RFI

To: Jordan & Skala Engineers, Inc. RFI #: 16
14240 Midway Road, Suite 350 Date: 12/28/2011
Dallas, TX 75244 Job: EB-02 Keller Springs Lofts
Ph: 469/385-1616 Fax: 469/385-1615 Phone: 877-777-5115

Subject: RTU 1,3,4,5,6,7,8

SHEET NUMBER
E-1.3

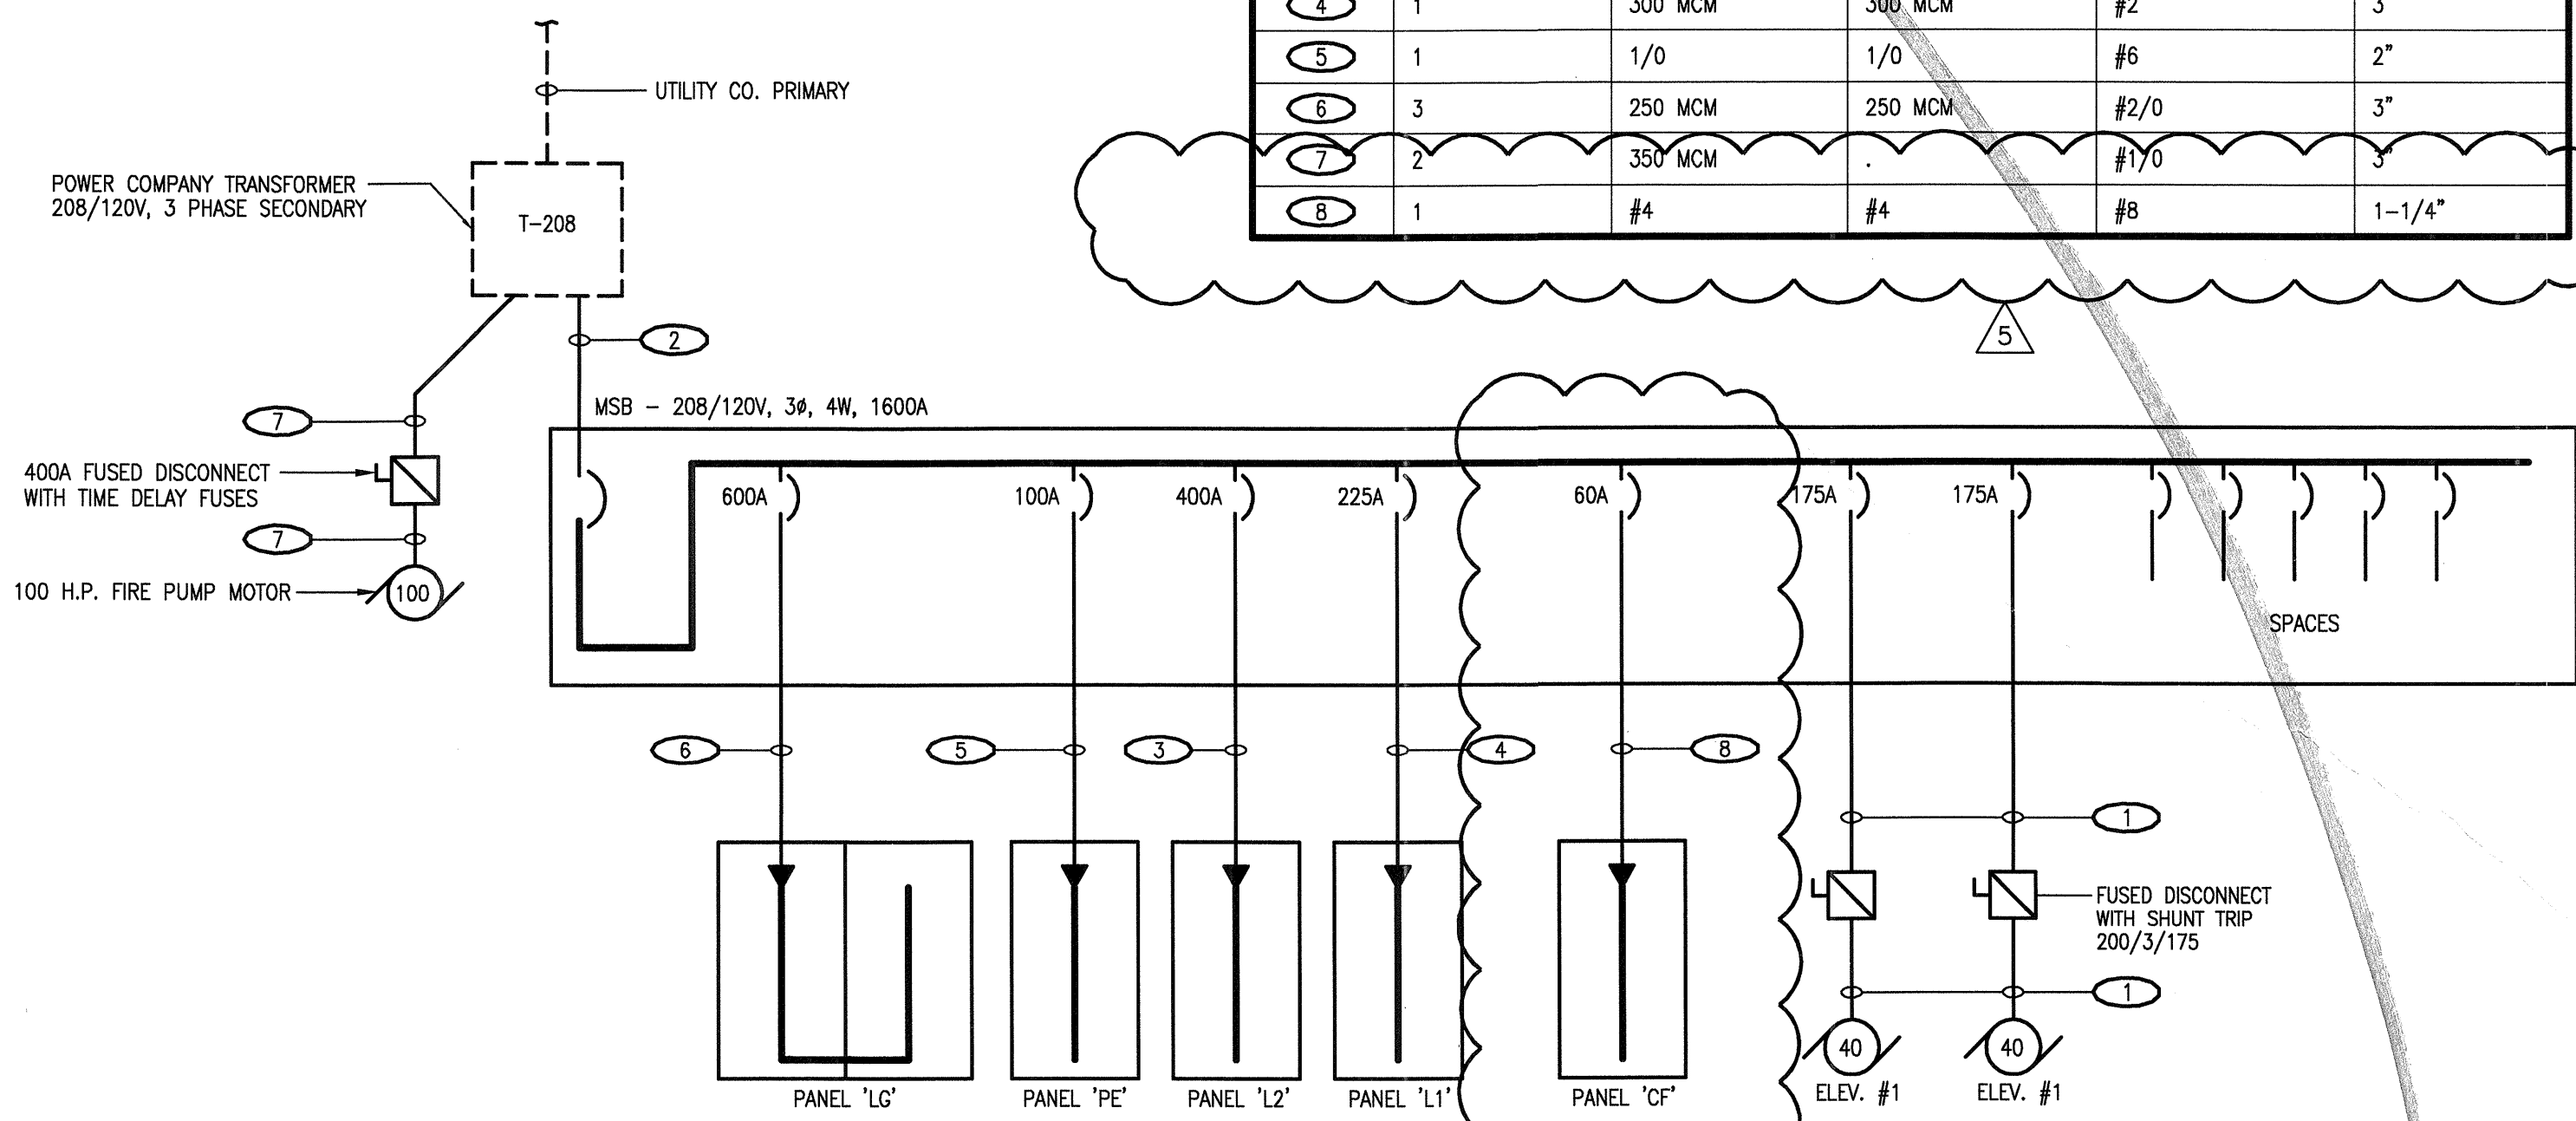
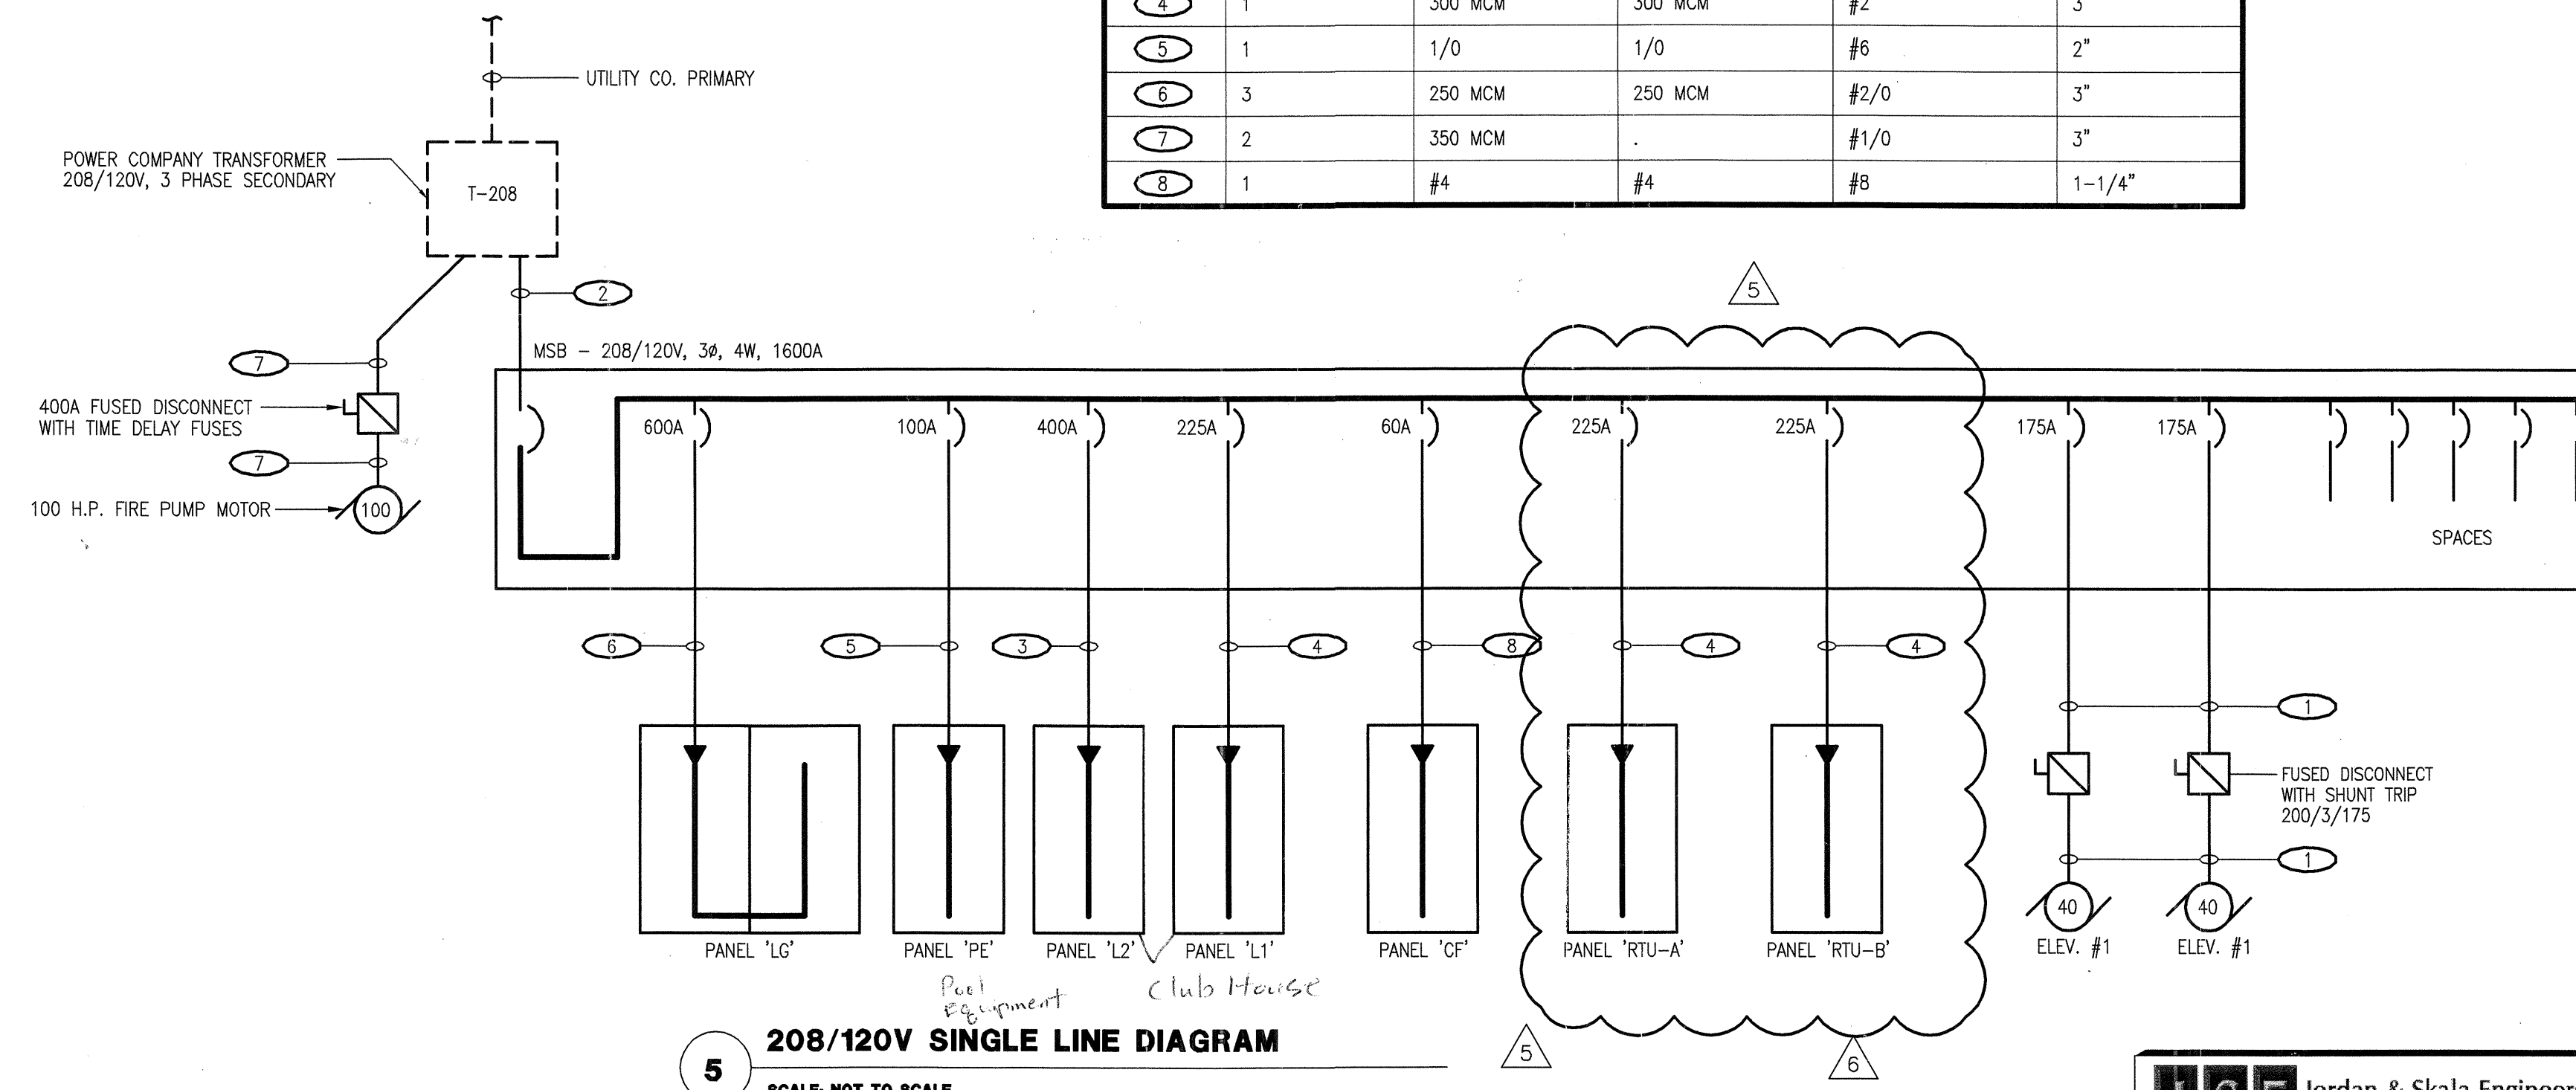
Request: Date Required: 12/2012
sheet E1.6 show RTU 1,3,4,5,6,7,8 being fed out of the house panel with 3 pole breakers house panels are 120/240V single phase according to TDI the HVAC subcontractor and attached cut sheets RTU must be 120/208V three phase we cannot feed 3-phase equipment from a single phase panel!

- MSF proposes the following solution
- 1) the RTU be deleted from the house panels
 - 2) RTU-2 be deleted from switchboard MSB
 - 3) add (2) 3 pole breakers to switchboard MSB that will sub feed (1) 3-phase subpanel in each building (RTU-A & RTU-B) that will solely dedicated to services the (4) RTU units in each building
 - 4) locate (1) of the sub panels (RTU-A) in the closet adjacent to HP-5 and the other (RTU-B) in the closet adjacent to HP-20
 - 5) feed RTU from these locations with wire type and wire size as indicated on our sketch and per our voltage drop calculations for 5% voltage drop using the actual load of 38.1 amps at 208V 3 phase

Response:
The above listed proposes are acceptable and have been incorporated into the electrical plans. Reference the attached E1.3, E1.6, E1.7, E3.1B, and E3.1D. The revisions have been clouded with a delta 6 for reference.
